## Conservation Comments - PDS

**To:** Acting Executive Planner  
**From:** Conservation Planner  
**Date:** 24 November 2017  
**Re:** SSD 7919 - Loreto School – 85 Carabella St, Kirribilli  
Documentation received 16 October 2017

LH-601

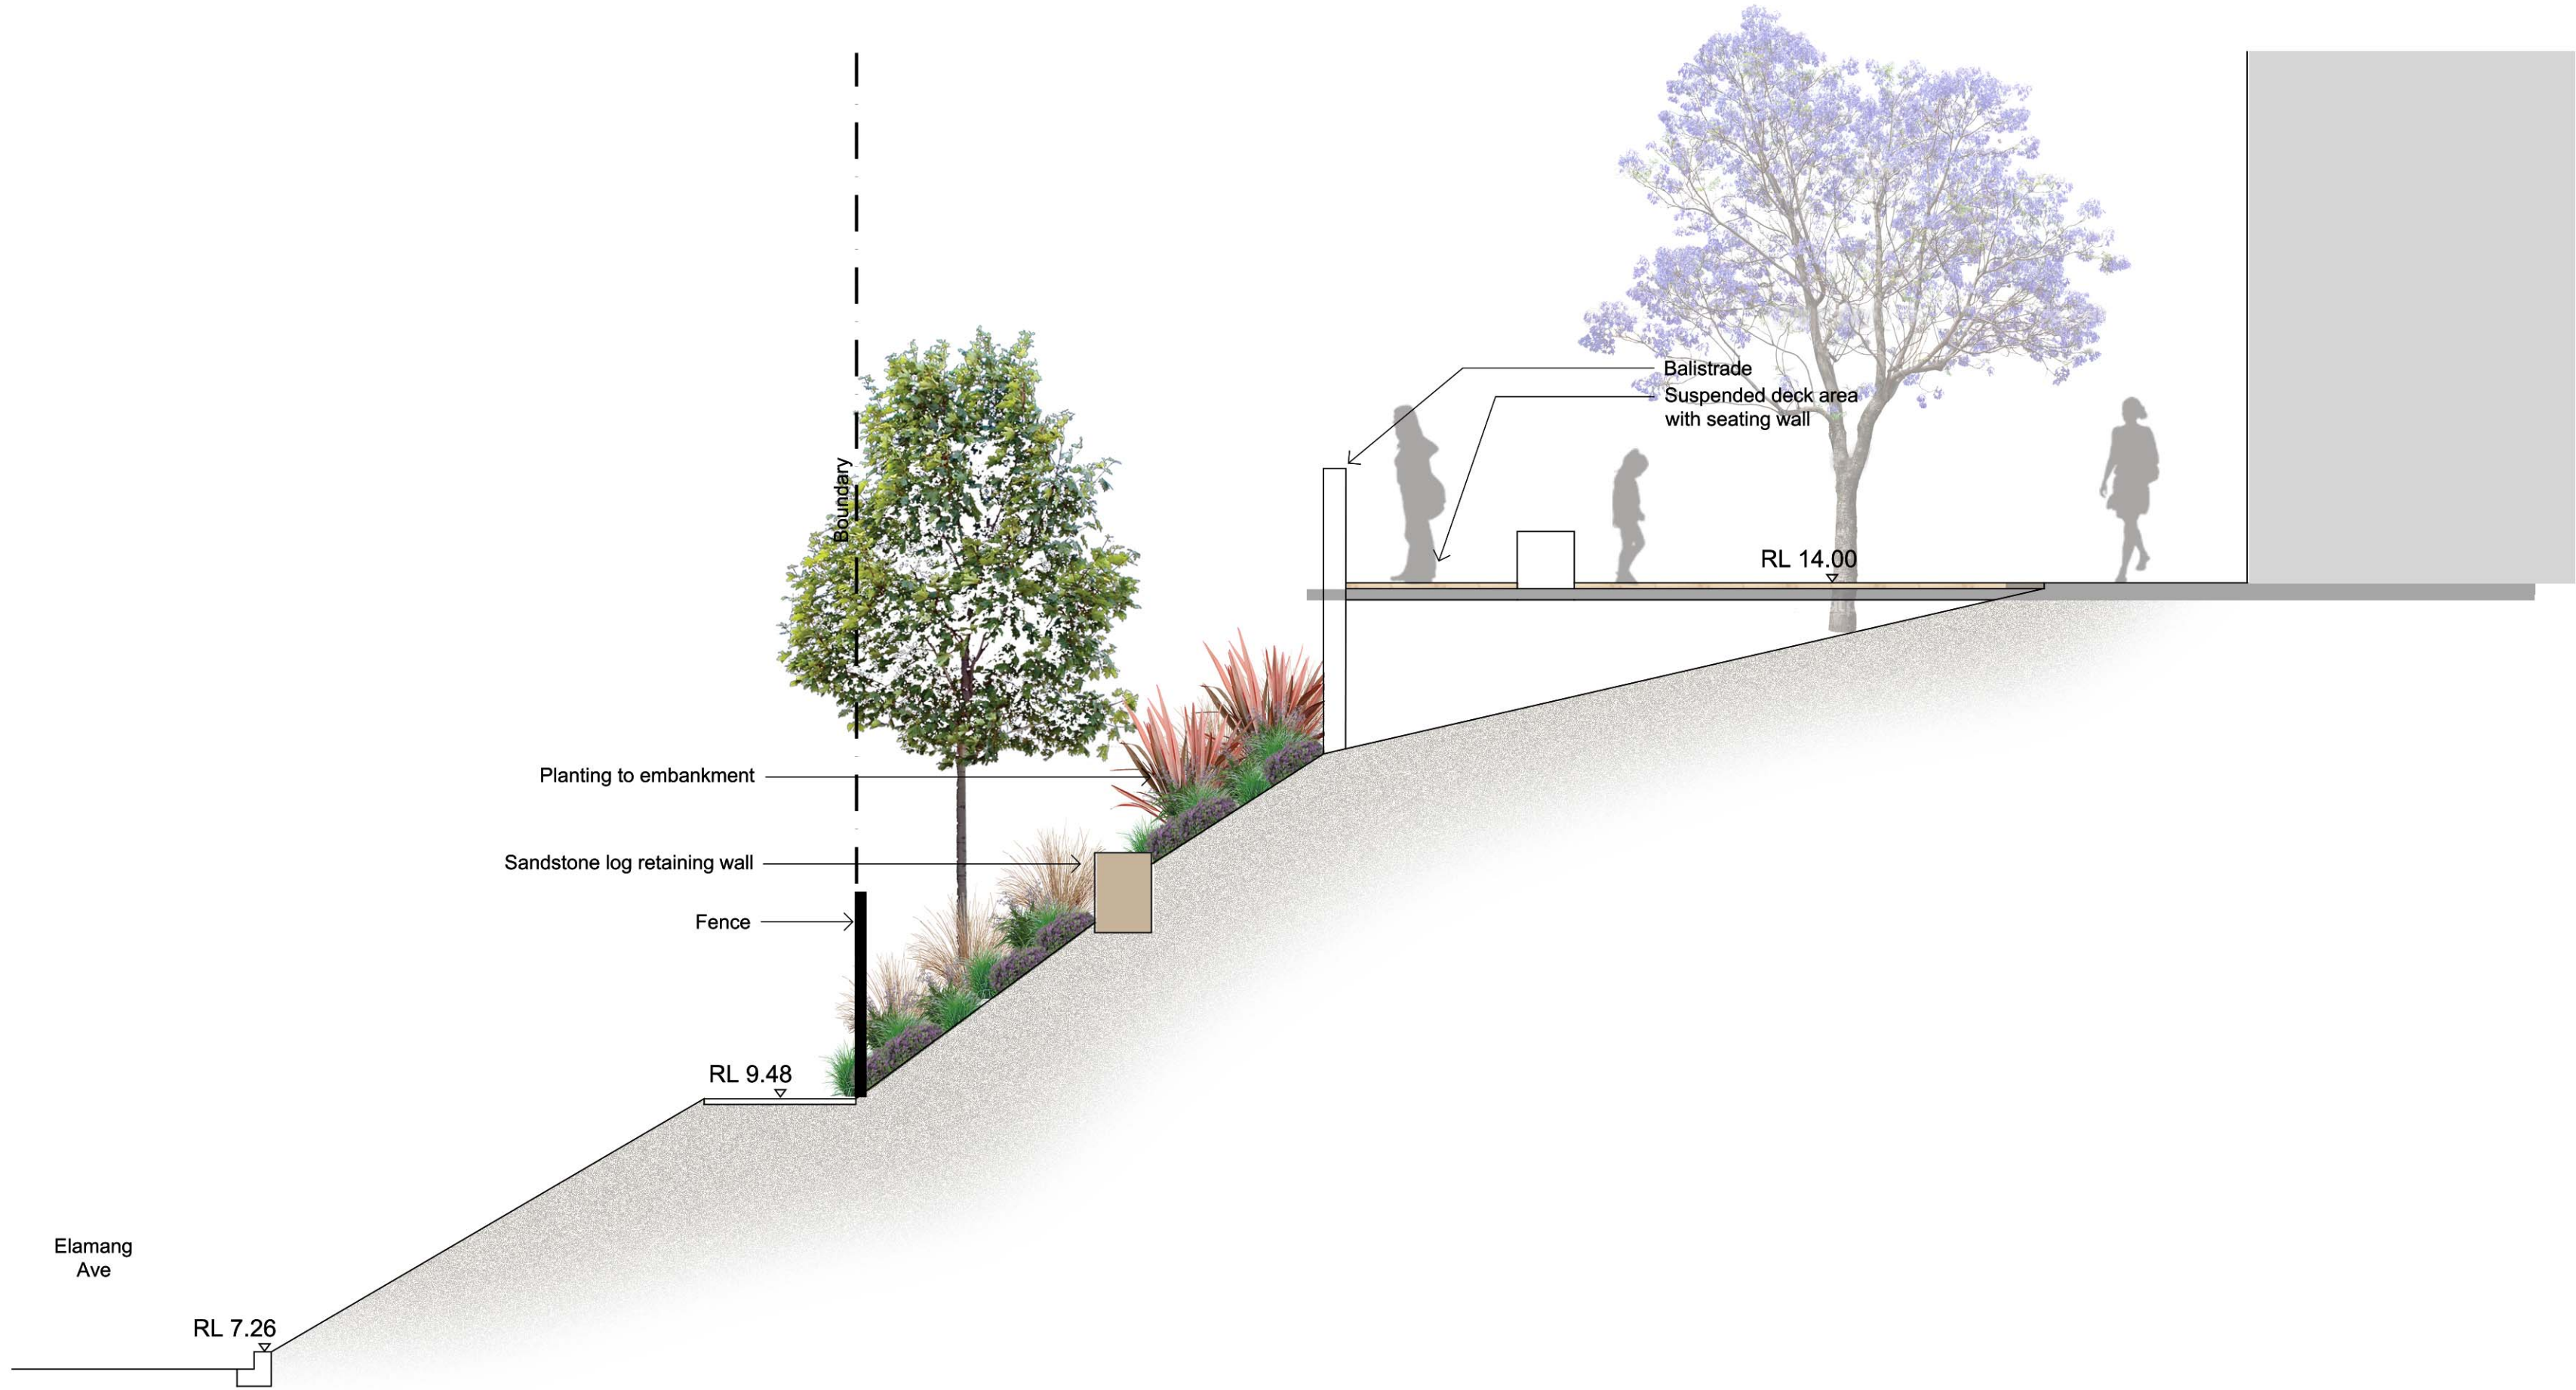
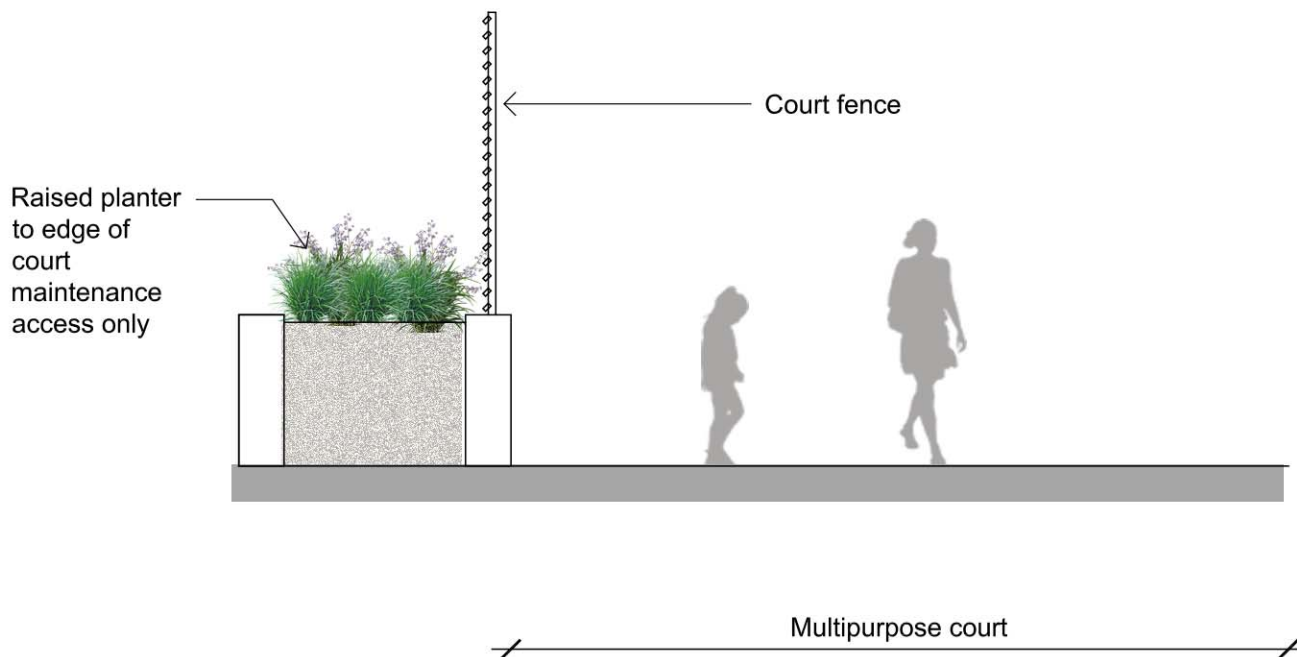
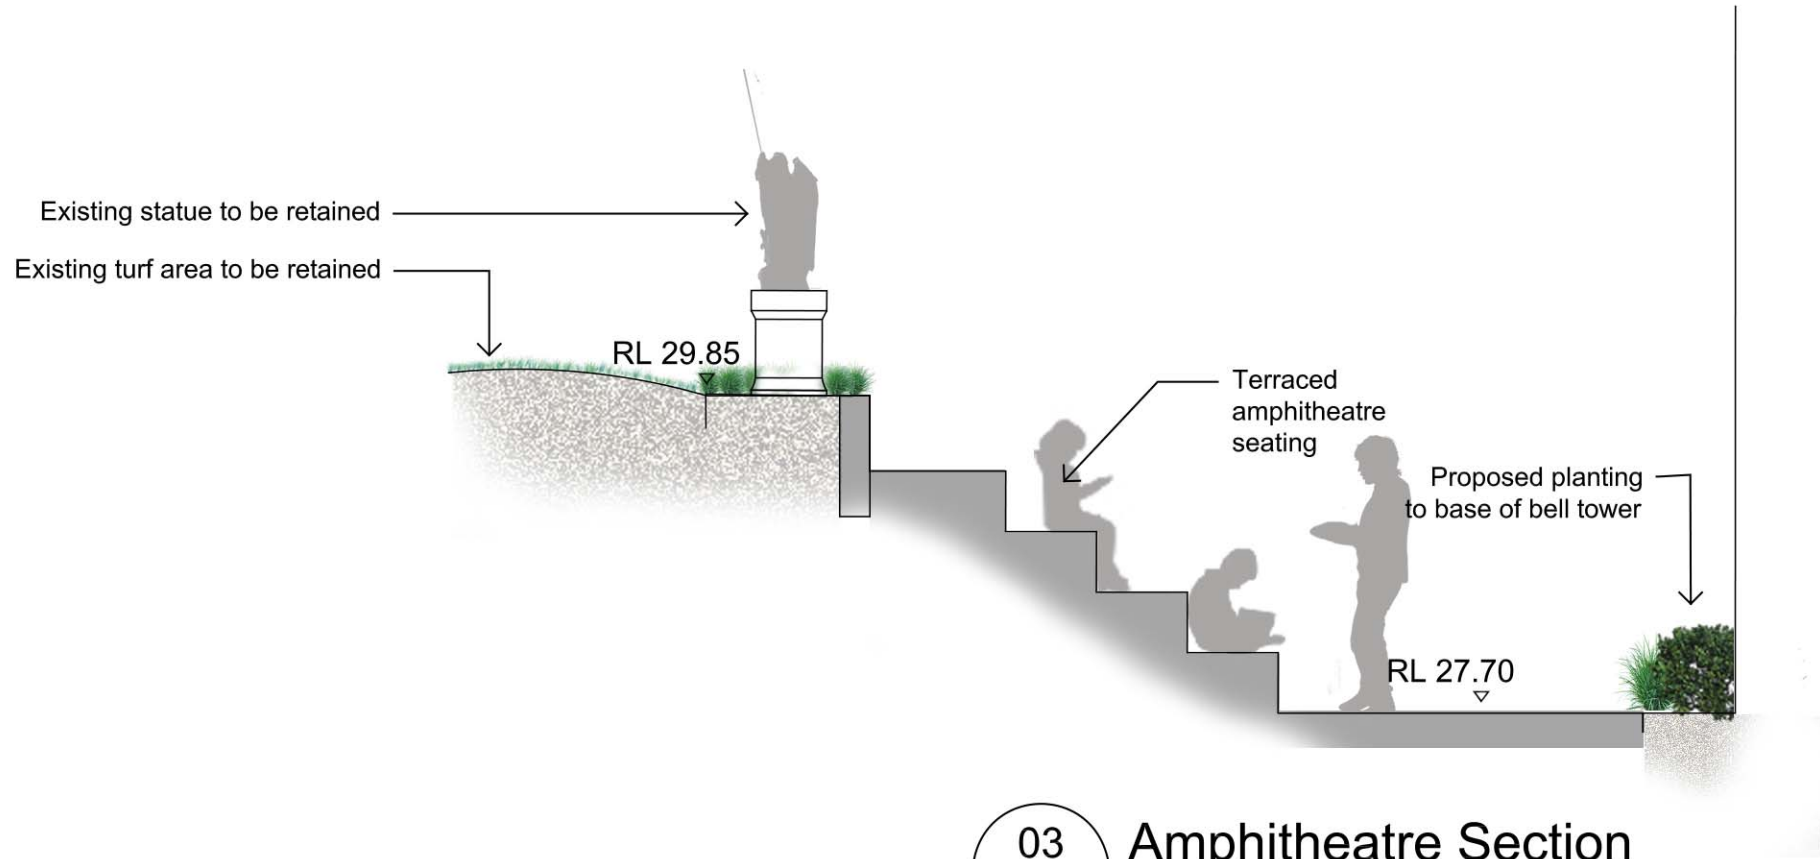
- Sandstone blocks from the demolished walls located between the B-Block and Marian Centre are to be salvaged for re-use on site and incorporated into the Landscape Plan. Sandstone 'log' retaining walls as shown on drawing LH – 601 Issue D by Site Image are not understood. Timber log walls are not acceptable, and sandstone blocks should be re-used on site.

- Landscape Plan required for the proposed amphitheatre adjacent to the Chapel, including sections. It currently appears to detract from the significance of the Chapel building due to the hardened surfaces.
